El Paso County
STORMWATER MANAGEMENT PLAN

Falcon Storage Subdivision

County Project No.: PPR2232

March 24, 2021
Revised
March 17, 2022
Revised
December 12-2022

1"=40'  
INTERIM CONDITION DURING CONSTRUCTION TO BE CONVERTED TO SAND FILTER BASIN

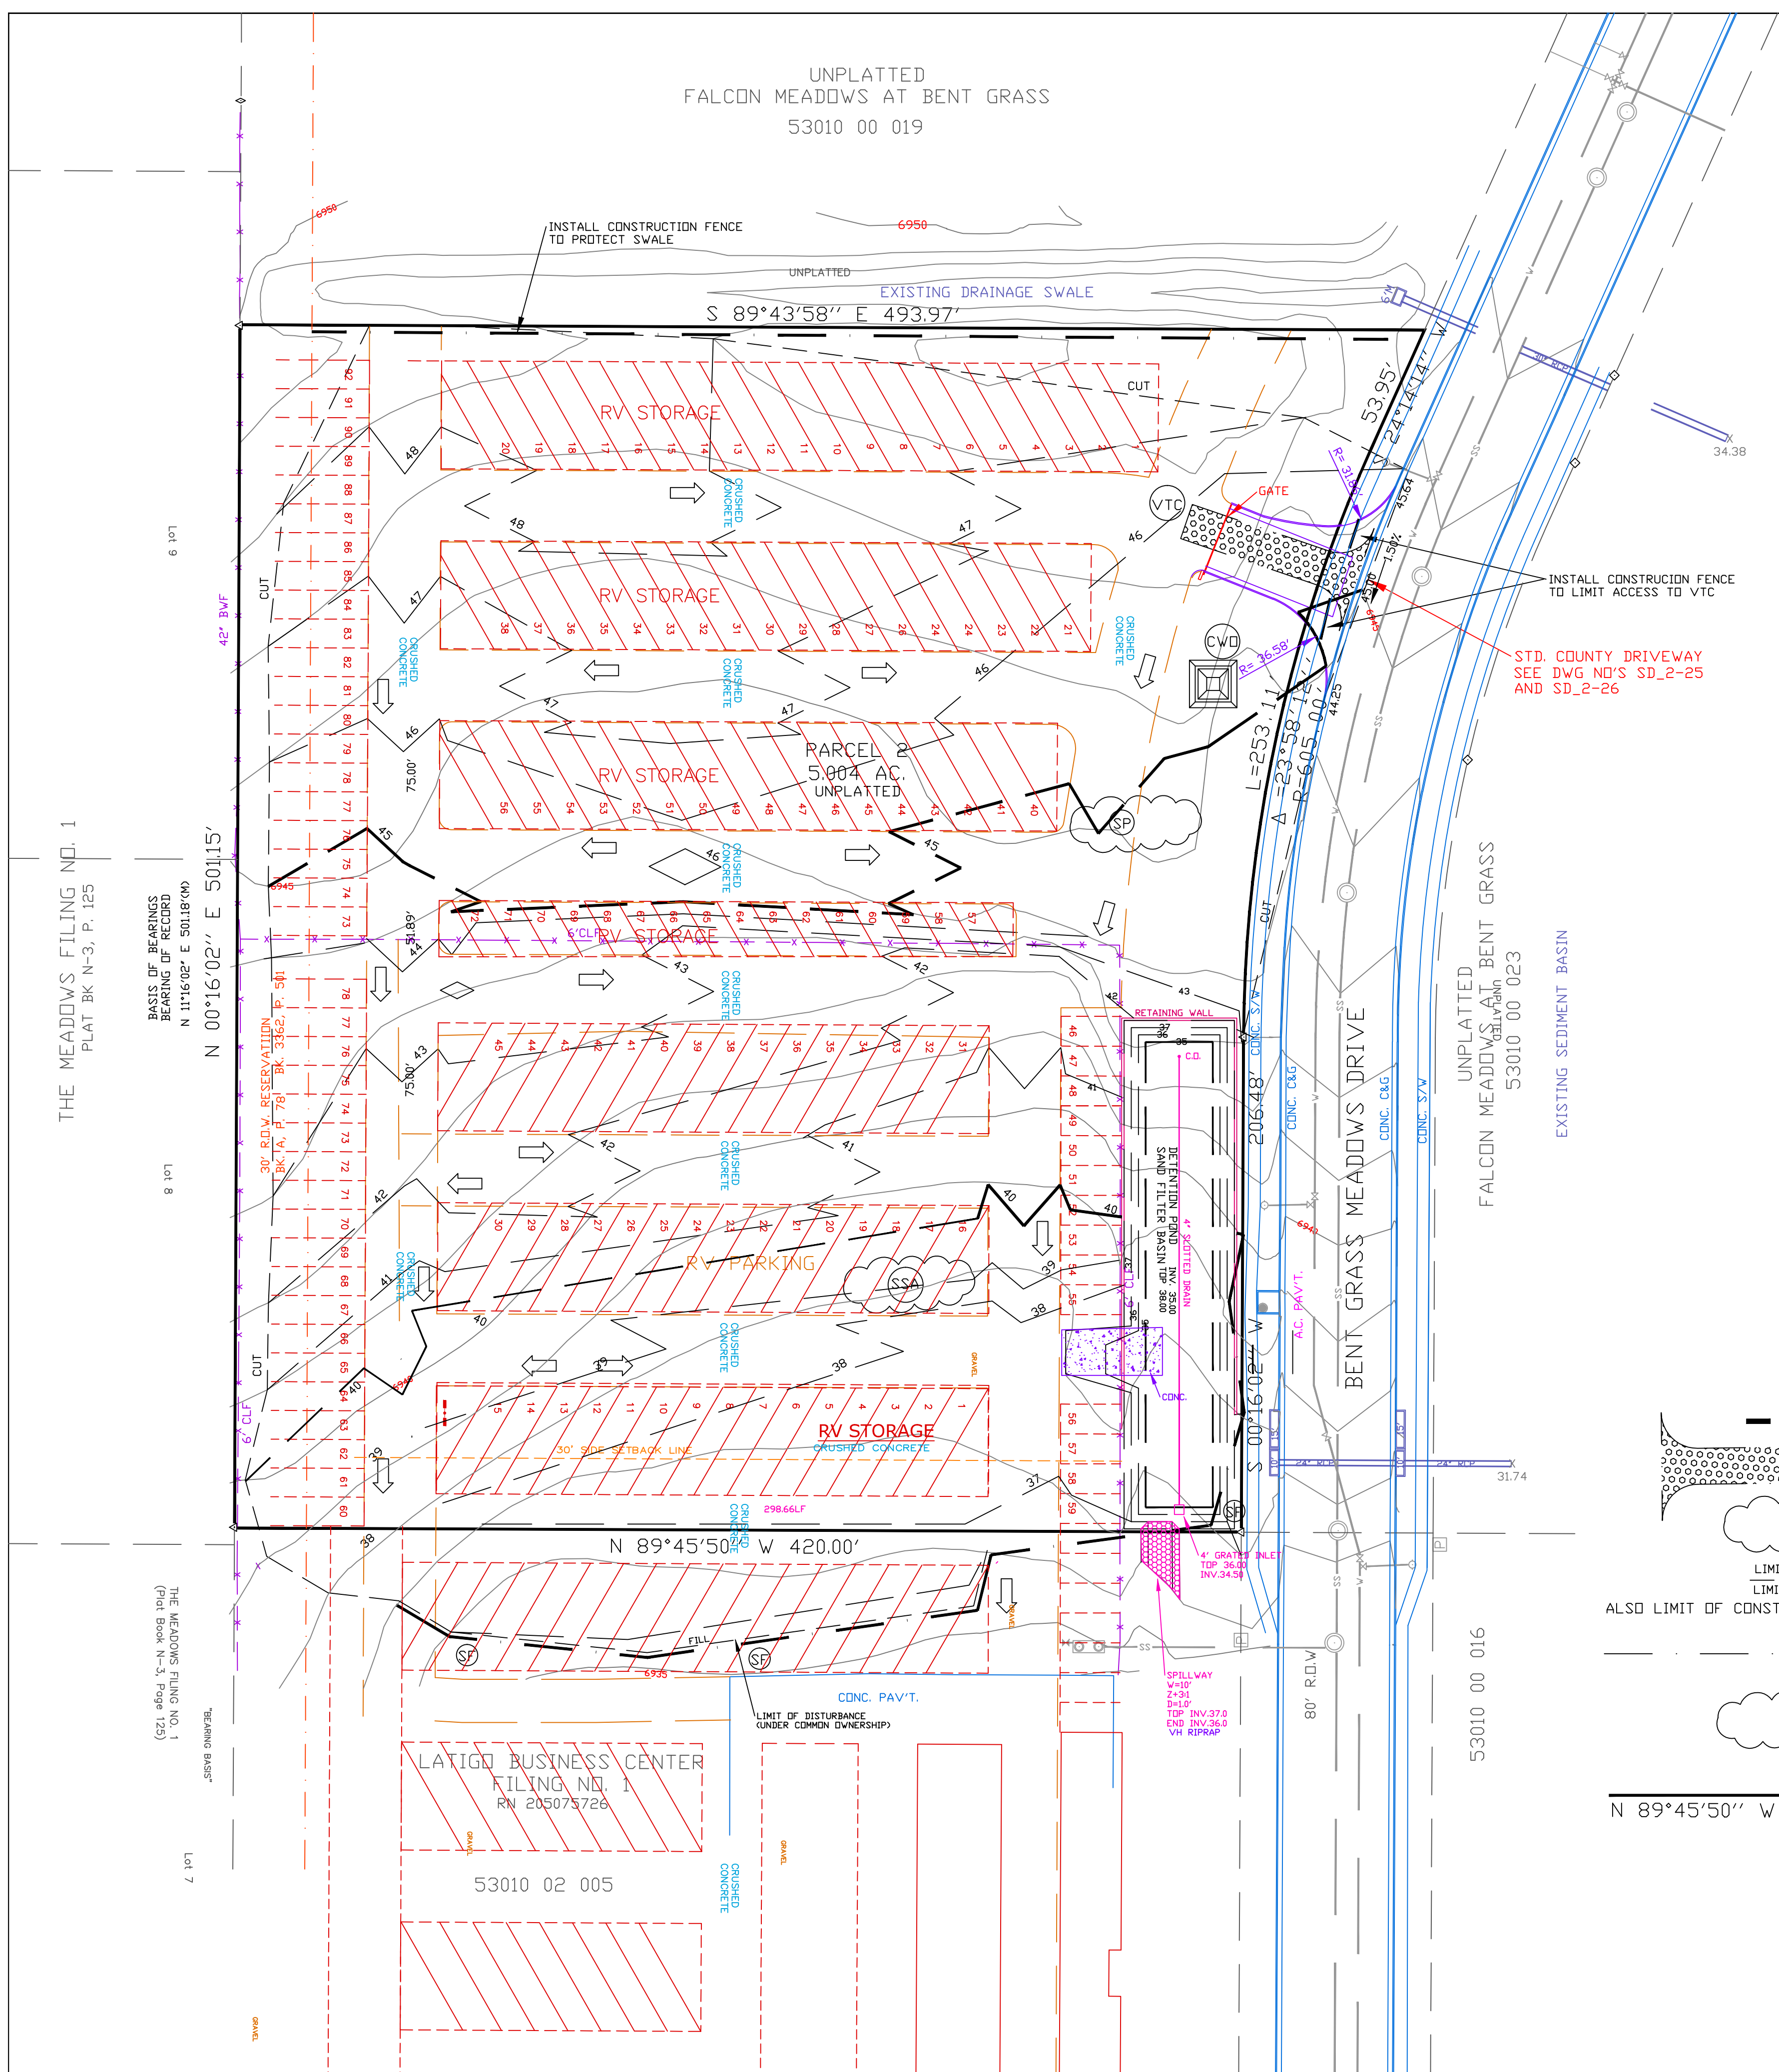
1) Structural practices: As indicated on the enclosed Grading and Erosion Control Plans, erosion will be contained through the use of said silt fencing or in the case of the project exit an VTC (vehicle tracing control pad). See Plans for locations and details on silt fencing and VTC. The portion of the lot that has experienced grading will be landscaped or reseeded per County Code (see DCM Volume II for details). discuss TSB. unresolved.

discuss TSB inspection and maintenance.
Unresolved.
